Subject: FW: Discharge of Condition application A-86-20-DOC - Local Highway Authority

Having reviewed the drawings and document referred to in the Civil Engineering Practice statement dated 20 May 2020, I confirm the highway authority's view on discharge of the conditions as follows:

6 drainage – no objection
11 travel plan – no objection
30 surface finishes – no objection.

Are you satisfied with the plans and information provided for **Condition 6**, **Condition 11** and **Condition 30** in discharge of condition application **A/86/20/DOC** for the Manor Nursery site, on High Street, Angmering?

DRAWN M Pacifico		DATE May 2019	PROJECT NO. 22995
ENGINEER S Magowan		CHECKED	REV.
SCALE As Shown @ A1		DRG. NO. 105	REV. A

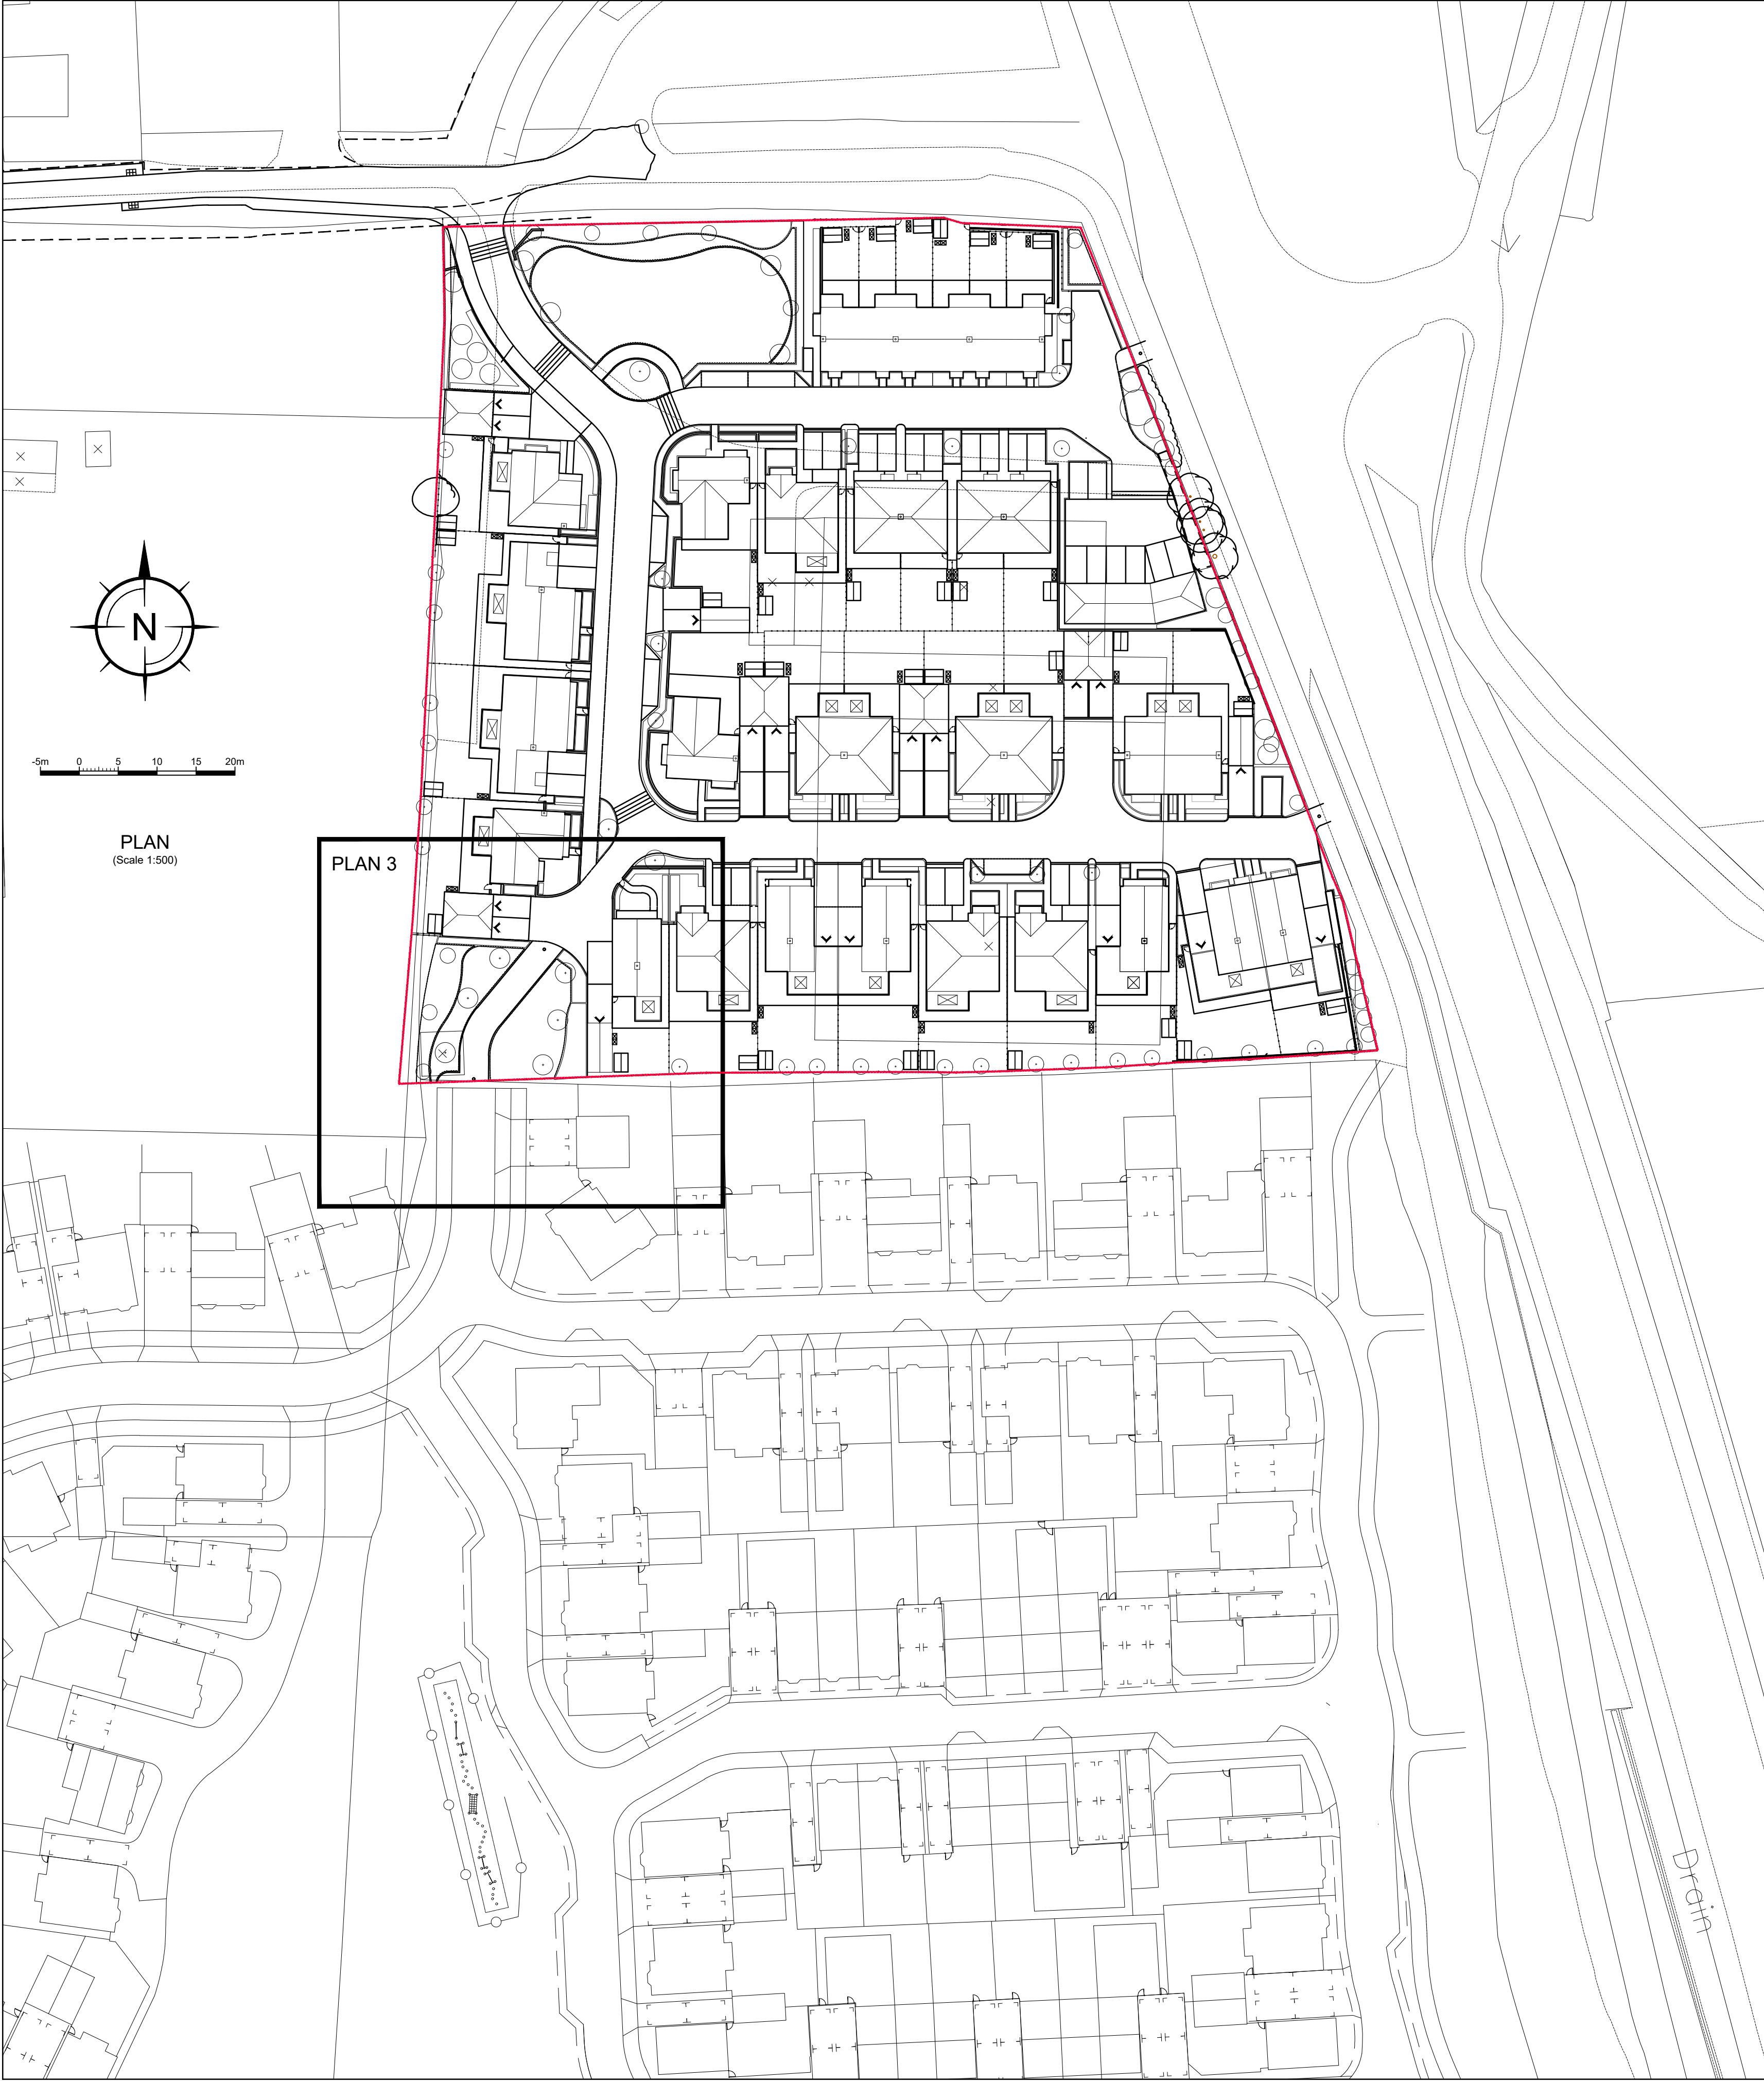
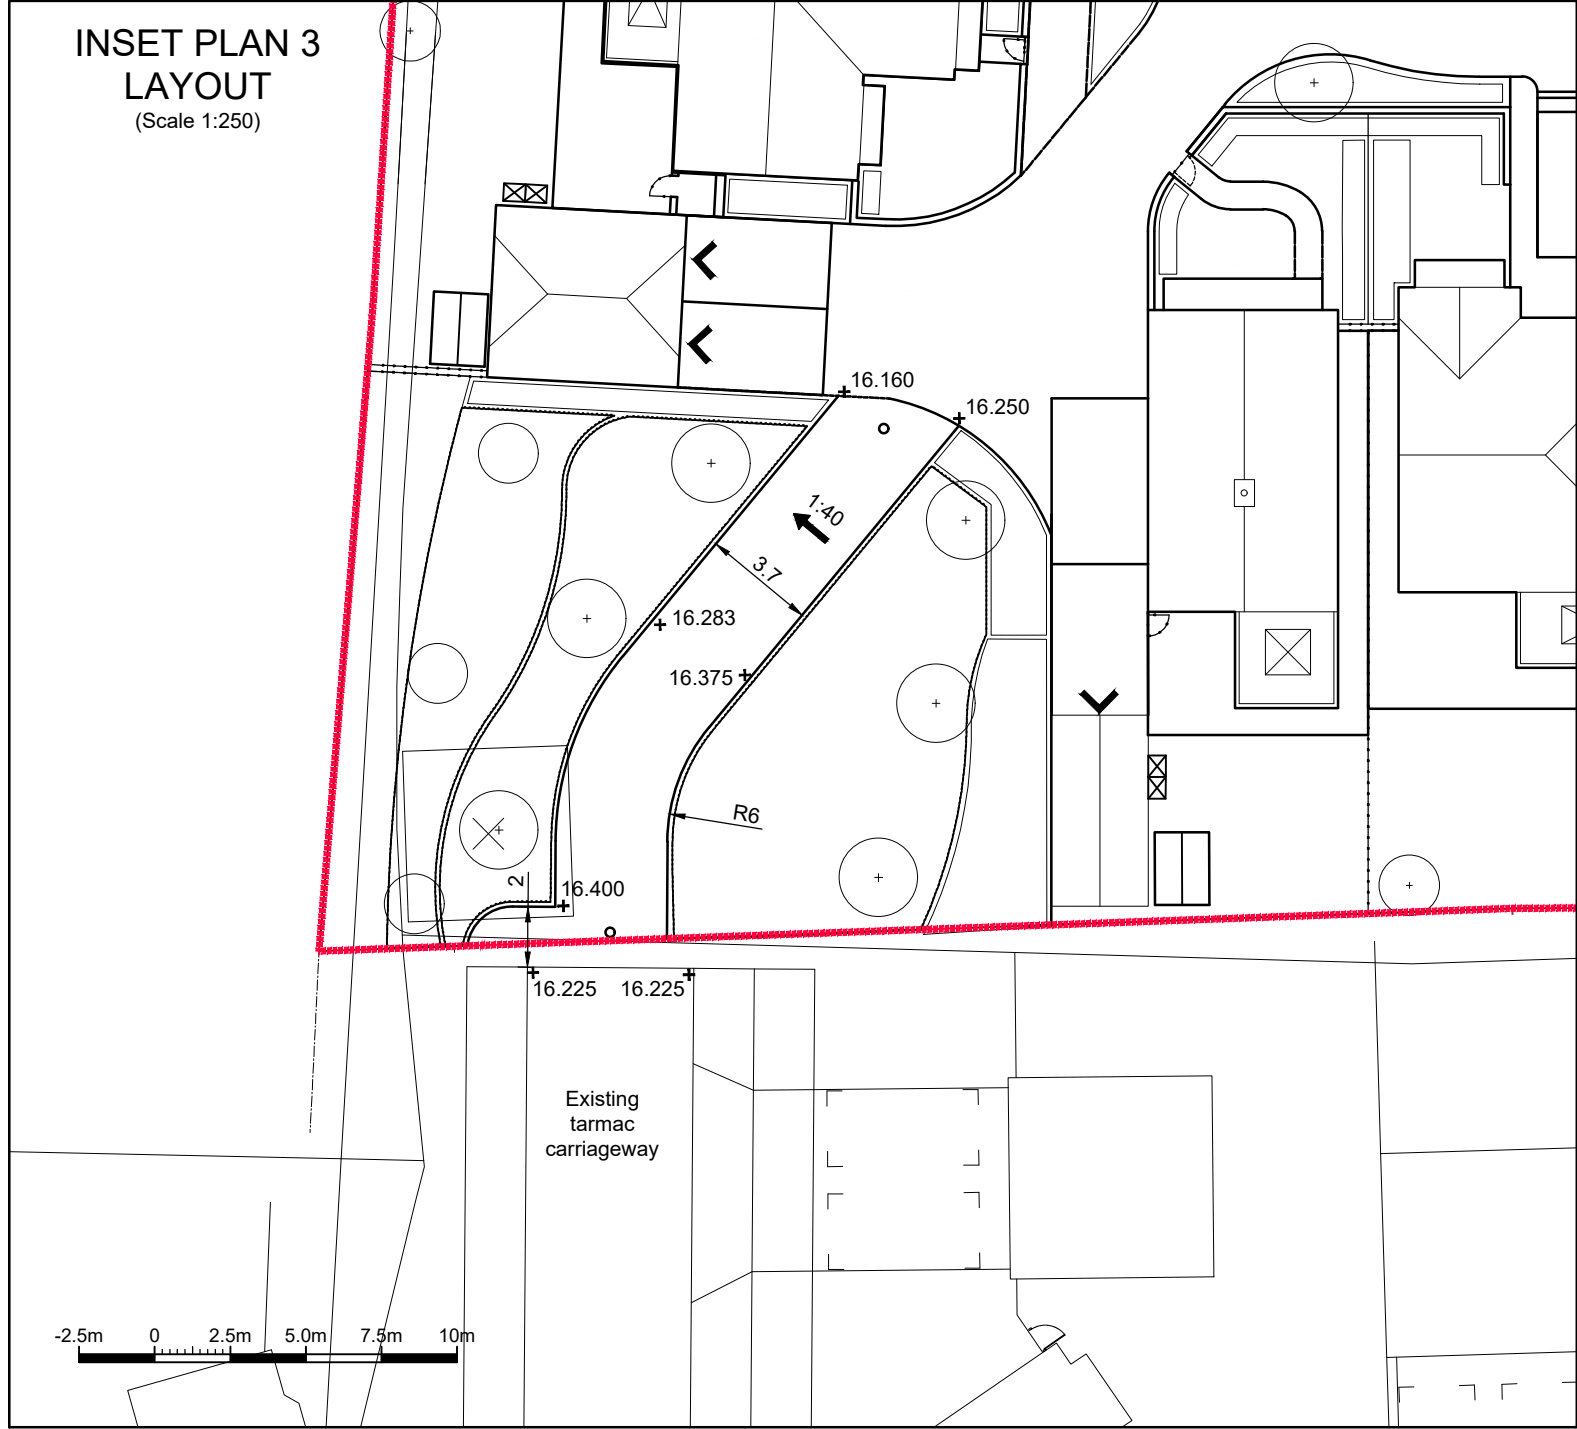
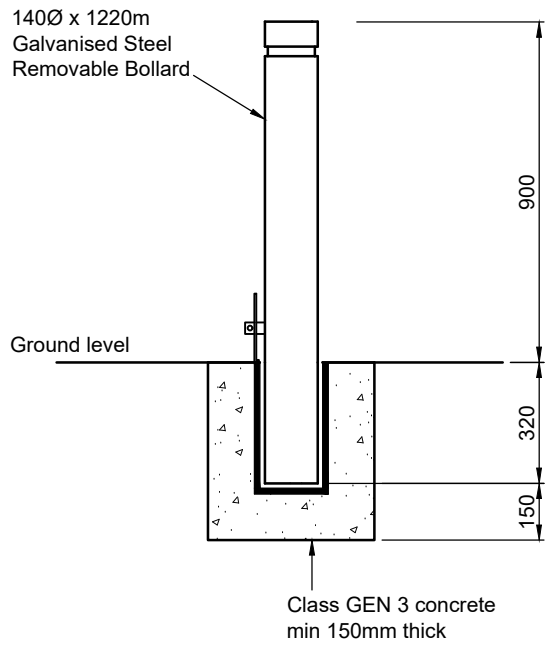
Cyclists would be able to join the highway of the development to the south as the access from Manor Nursery to Land to the east of Roundstone Lane would join up as illustrated in the Site Layout (105 A).

The layout as illustrated in Site Layout (105 A) is the same as the site layout as approved under the Reserved Matters application (Proposed Site Layout reference 100 P9). In this regard, it is considered that Condition 29 has been addressed in full and has already been agreed by WSCC Highways during the determination of the RM application (refer to WSCC Highways attachment dated 3 October 2018).
